liquor license

| Lio Restaurant | 3 Spring St, Portland, ME 04101 | coming soon.

Jon Rioux and I reviewed the permit records this morning, I believe he has contacted you. See the list below of what is required to move forward with the issuance of the CO and Business License.

SECOND FLOOR PLAN

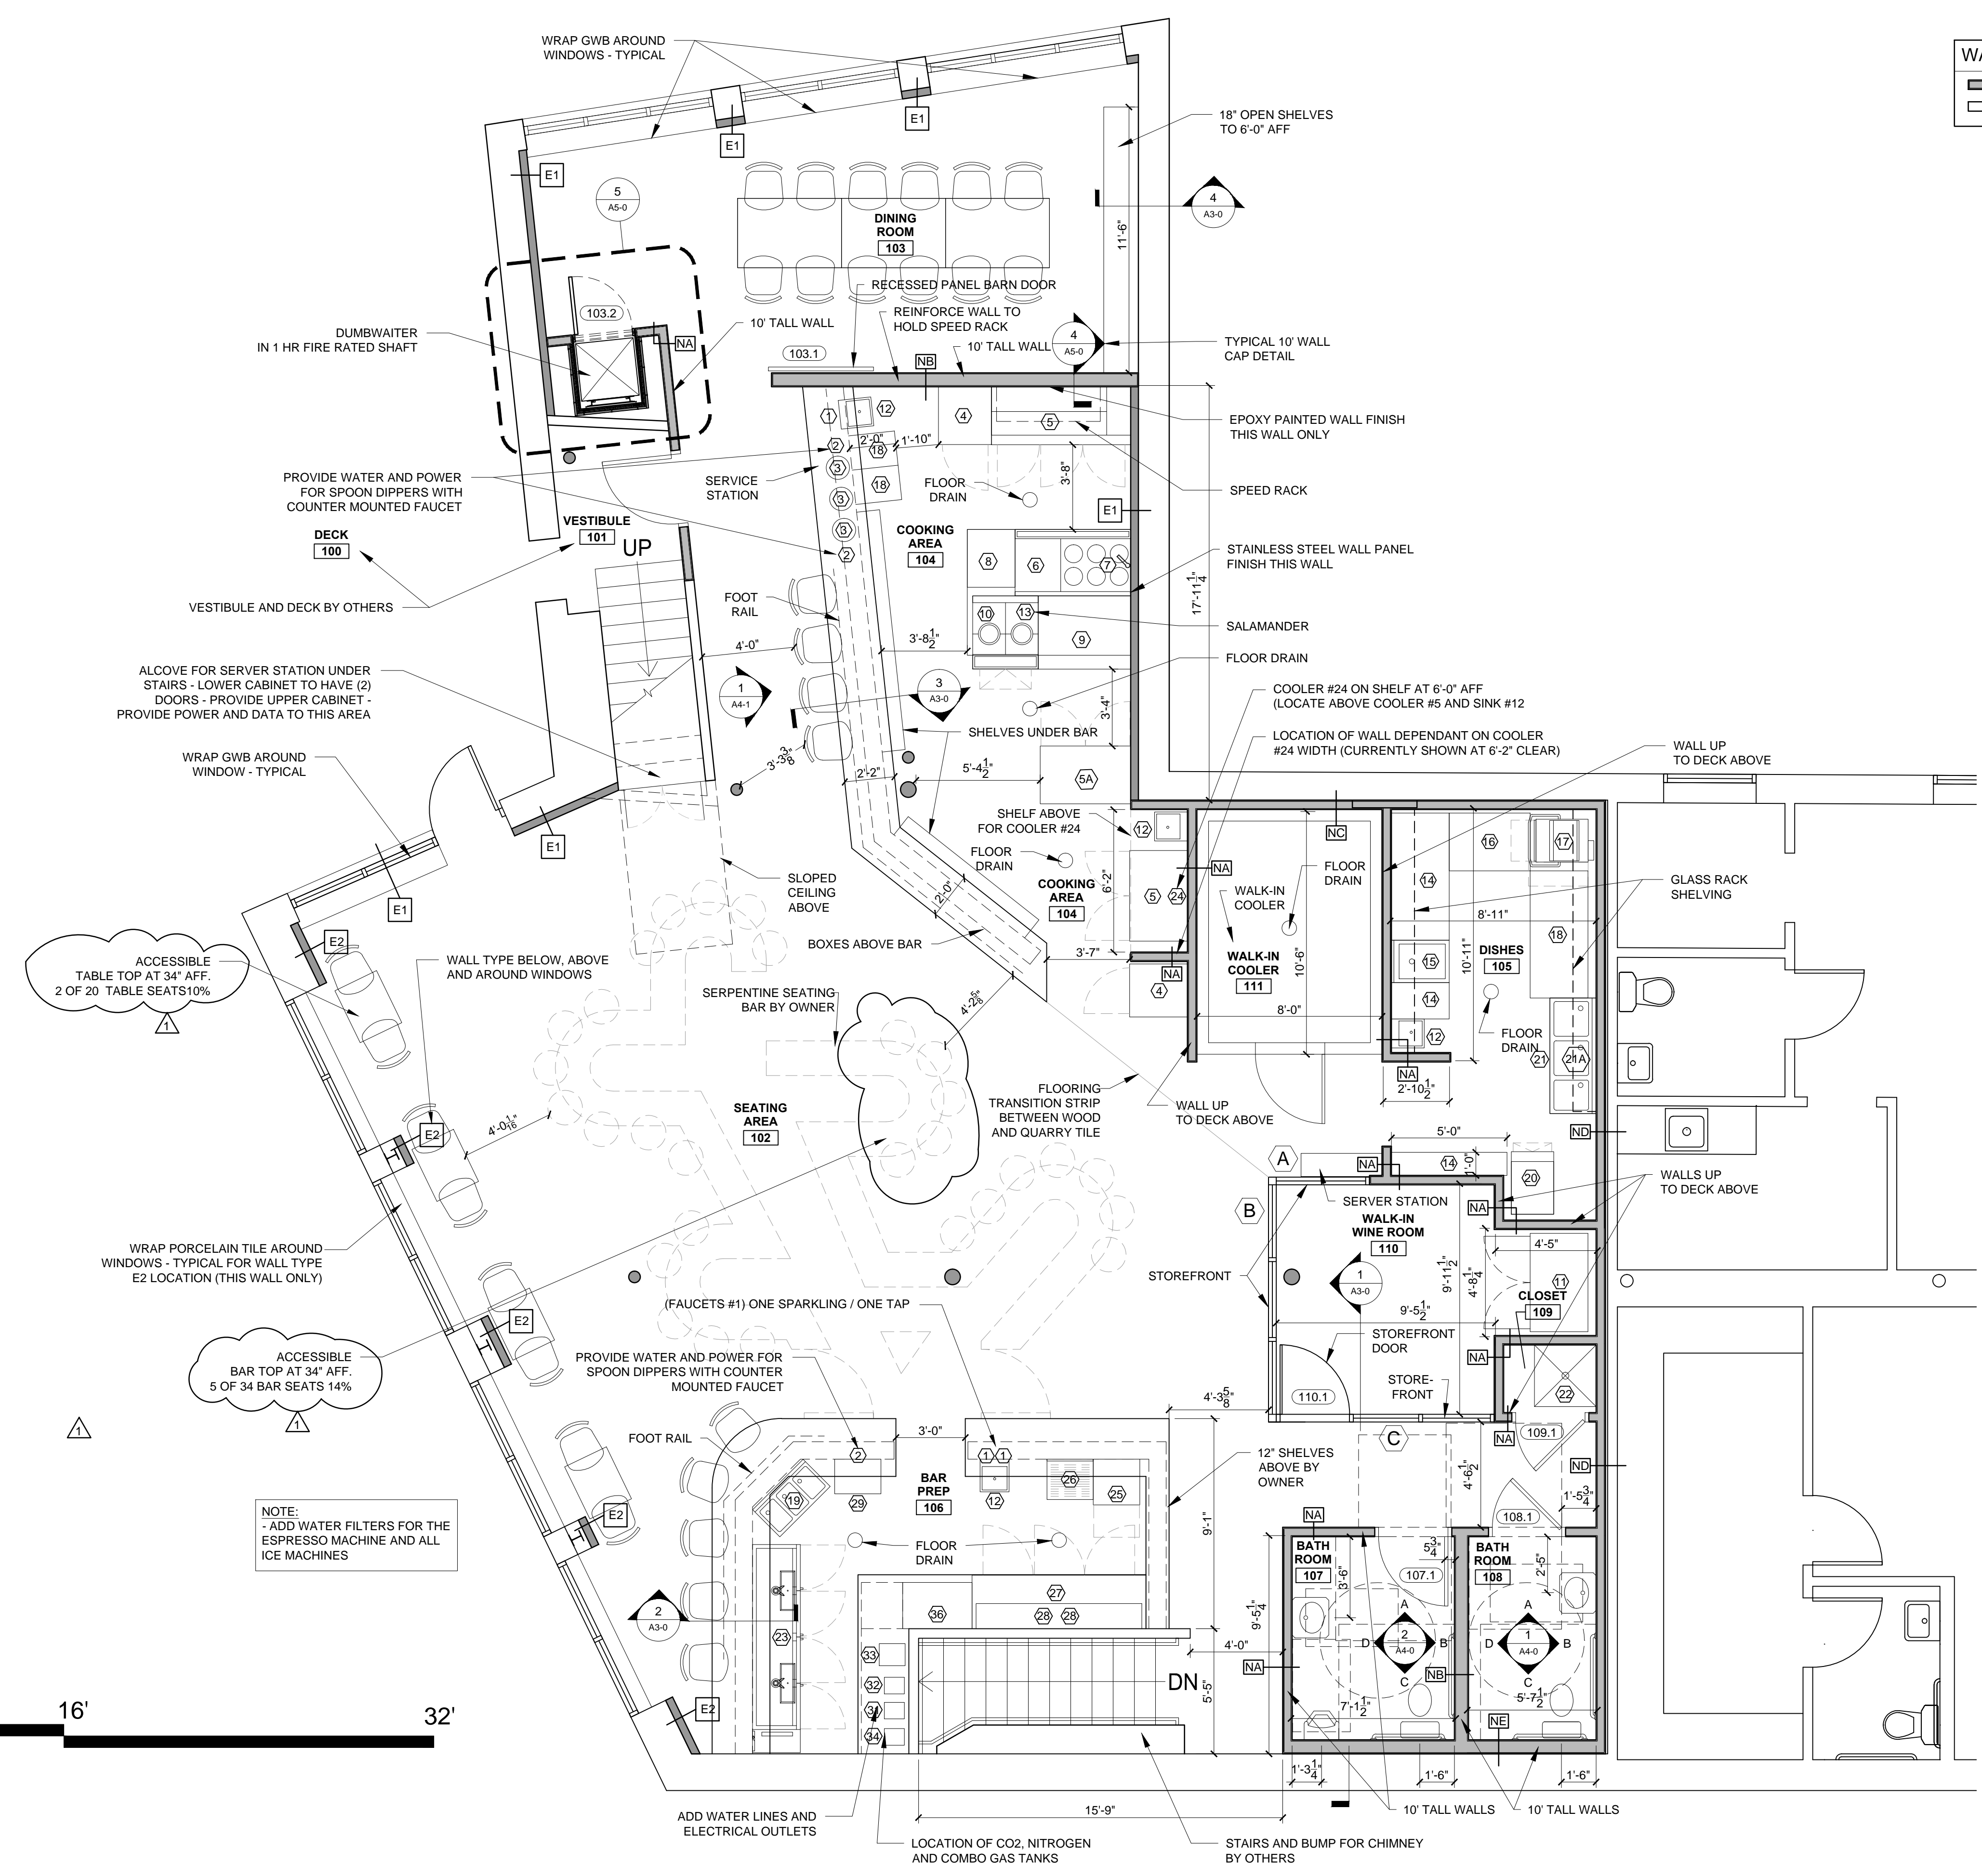
2. An updated floor plan for the 2nd floor identifying the number of fixed seats, and the square foot dimensions of the areas with tables and chairs. The State plan shows 4 top tables along the exterior wall while the architects plan shows 2 top, please clarify that this will allow a minimum 3' aisle clearance for egress. Include the square foot area of the deck and how it will be used, e.g. standing, tables & chairs. Also, was the dumbwaiter installed? The plan for the State notes POS (Point of Sale?)

1. The seating plan no longer shows seating at the kitchen bar, is there a bar built to accommodate seating at any time?
2. The dumbwaiter is not shown on these plans, was it installed as per plans as a 1 hour rated shaft and door assembly?
3. The deck is part of the approved tenant space and is therefore required to have an occupant load for the CO. The square foot area needs to be calculated for either tables and chairs (15sf/pp) or standing room (7sf/pp). This needs to be consistent with the amount on the business license. Access to the basement bathroom is required, how will this be achieved? The health inspectors will need to approve any travel through prep areas.

The restaurant has 30 fixed seats around a central bar, 5 seats at the main bar, 12 seats on the window wall, and 16 seats in the private dining room, for a total of 63 seats (or which 30 are fixed). There are plans for another 20 seats on the patio (5 tables of 4), but it is presently unoccupied. There is ample room between the tables against the wall and the back of the fixed seats, easily 3 ft, typically 5+ ft.

2. The dumbwaiter is installed per plan, the shaft is 1 hour fire rated, I don't know about the door, but will have someone look at it and make sure it is also 1 hr rated.
3. Ryan Senatore tells me "the deck is 243 sf (excluding egress pathways to the doors) so 243/15 for tables and chairs it is 16 occupants on the deck
4. We can provide access to the basement bathroom most easily through the kitchen prep area – there is a clear pathway around the kitchen prep area so patrons will not have to enter any of the prep areas, and we could delineate this further if necessary.

1. The 4 seats at the kitchen bar will be added back into the seating for a total indoor of 67.
2. I understand the dumbwaiter door will be changed and rated.
3. The occupant load of the deck will be added to the CO.
4. We can have one of the health inspectors check next week on the bathroom access and to see if anything needs to be changed.

SHEET TITLE:  
LIFE SAFETY -  
BASEMENT PLAN

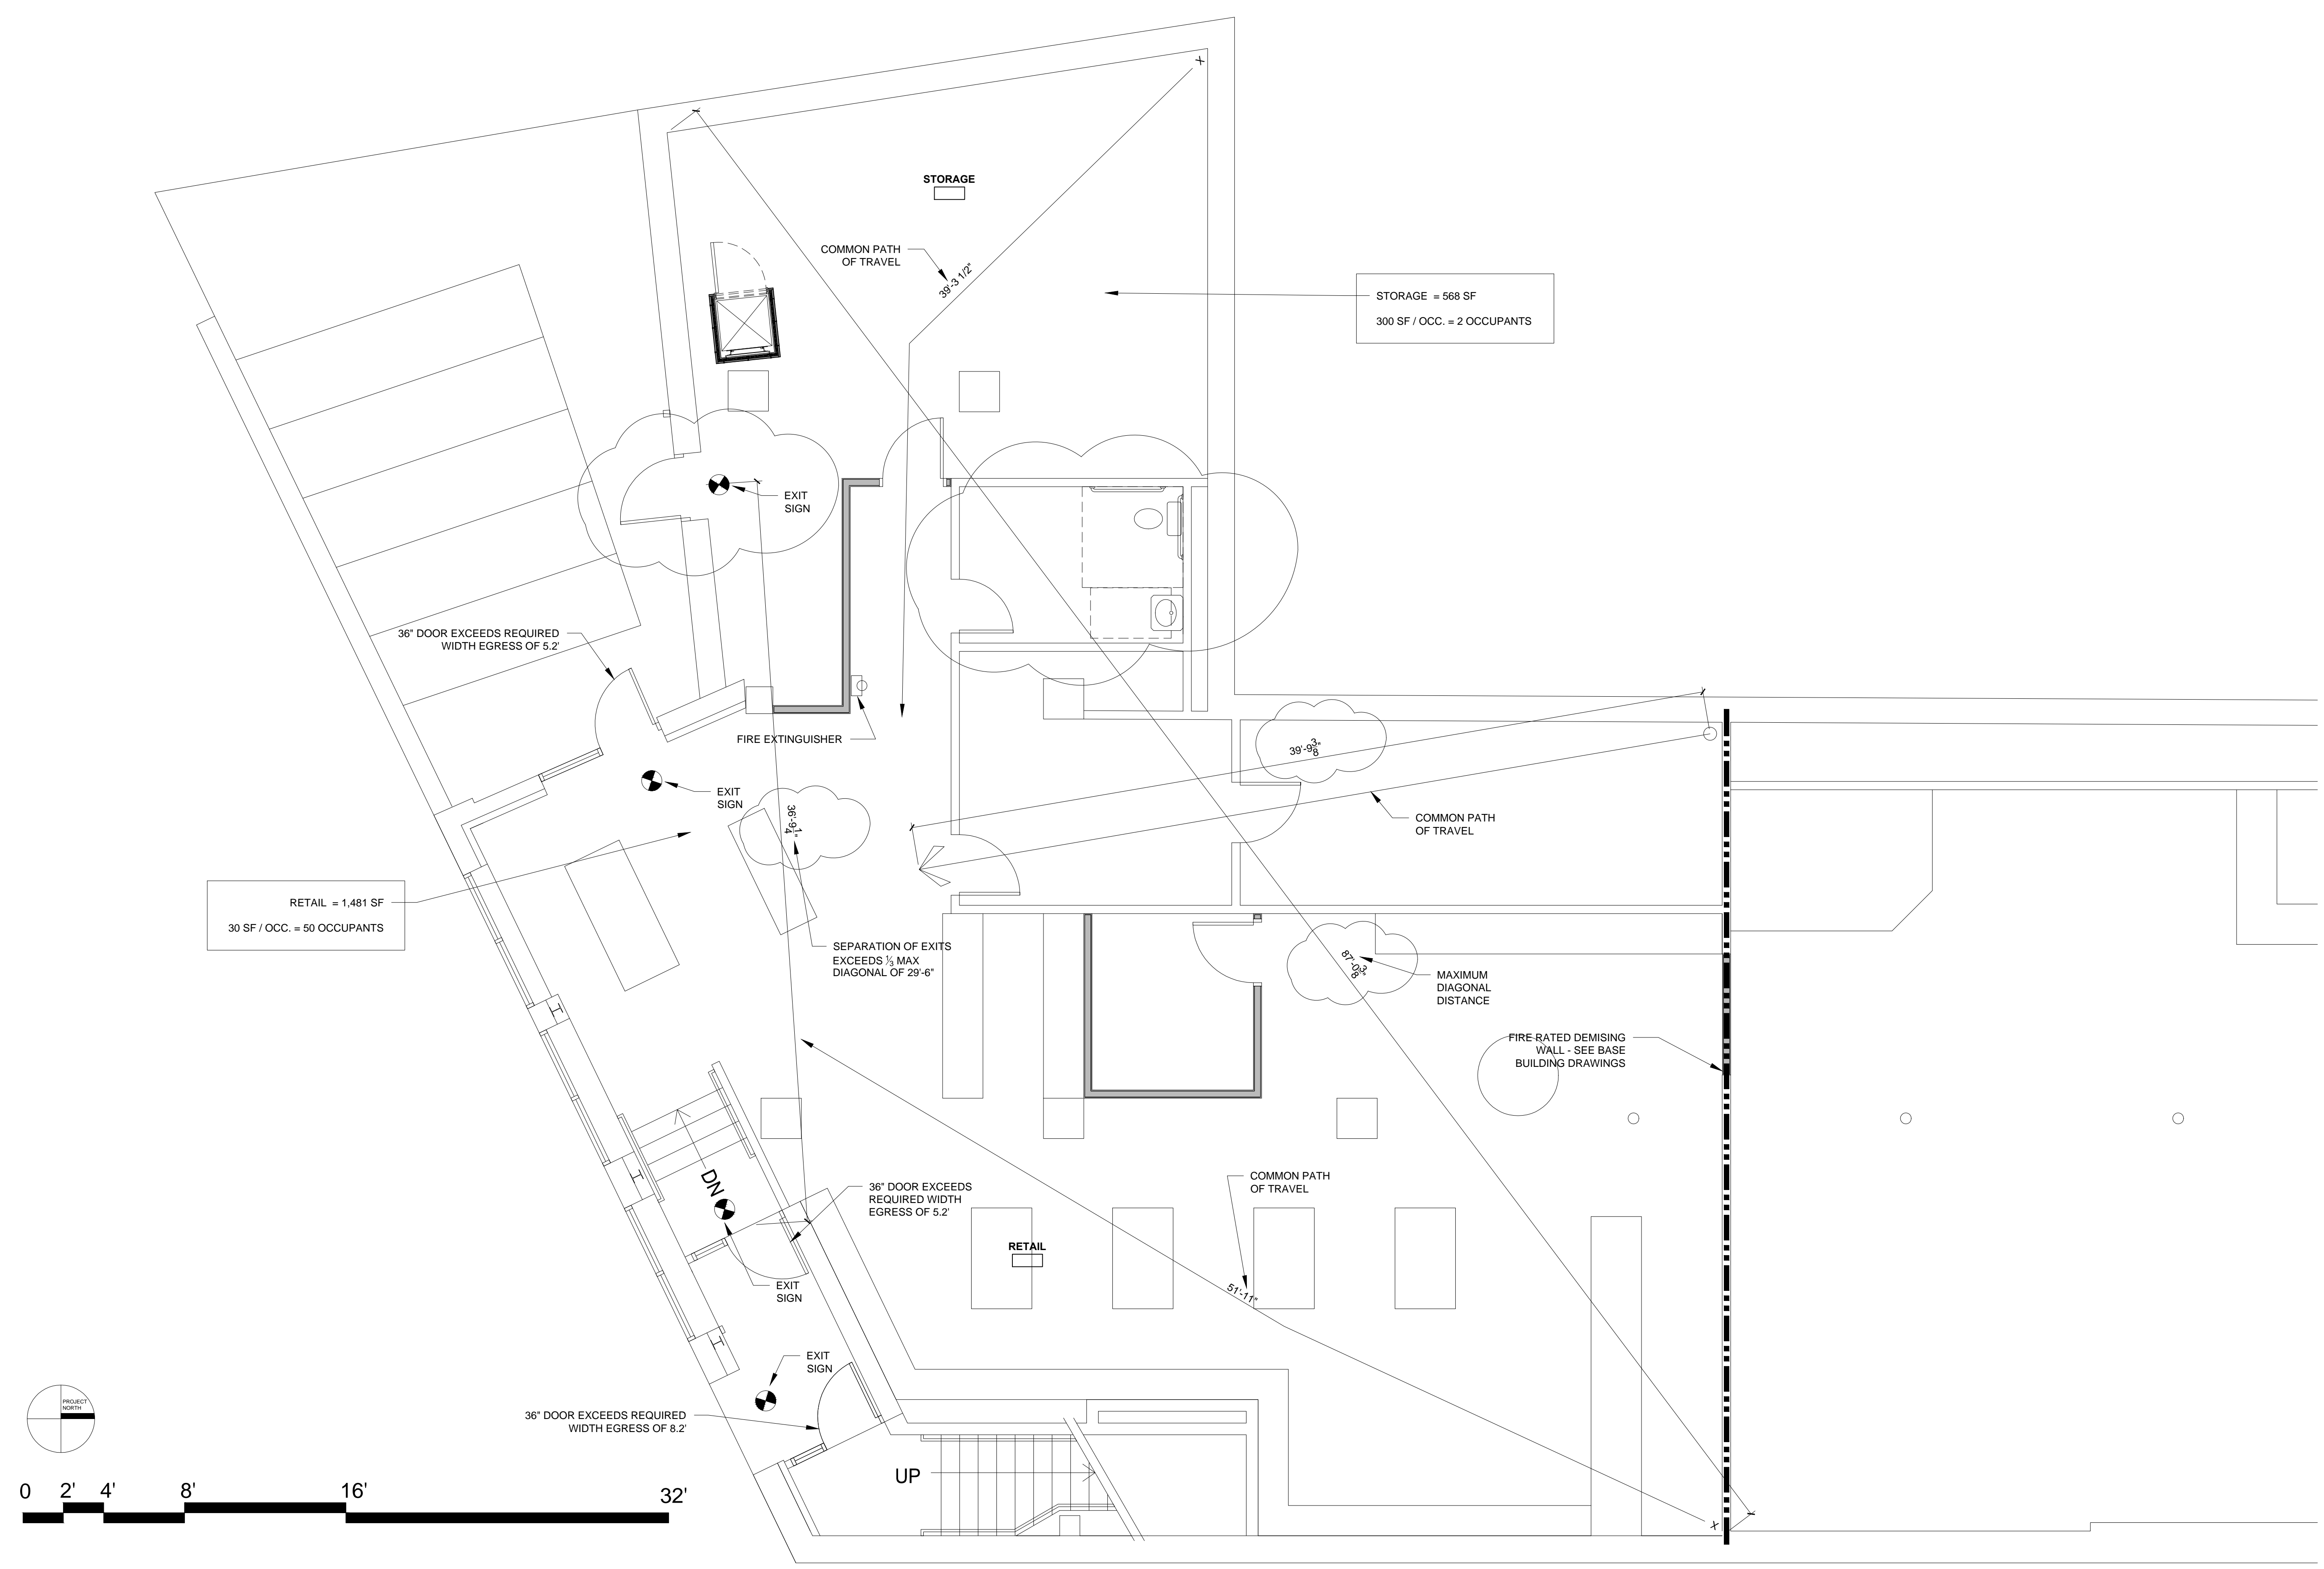
1. An updated floor plan for the lower level identifying occupied and unoccupied areas and the patio. The plan submitted for the outdoor seating license will work, if it is the current layout, however the patio dimensions are illegible, please clarify for square foot area calculation. Based on the occupant load information thus far, the bathroom on this level will need to be available to patrons.

The deck was previously approved for a drink rail and central table, but is presently not used. The patio has a gross square footage of approximately 600sf, subtracting the stairwell space 483sf.
